Epping to Thornleigh Third Track Proposal. Application number SSI 5132.

NO GOVERNMENT REGULATION OF NOISE AND POLLUTION FROM THESE TRAINS.

Figure S.6 Cross-section and elevation - New Cheltenham Station concourse building (see also S.5 for artist's impression)

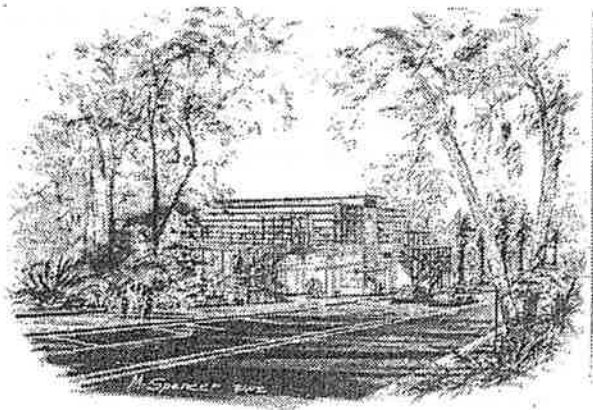
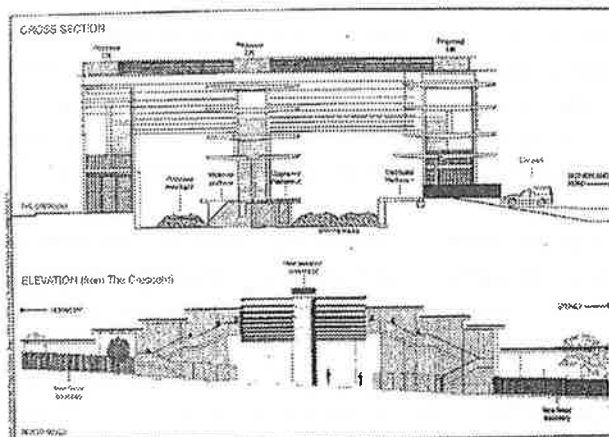
- The proposed redevelopment of Cheltenham Station shows no regard for the HCA. The visual impact of the proposed 13m high glass and steel concourse is totally unacceptable in this HCA.
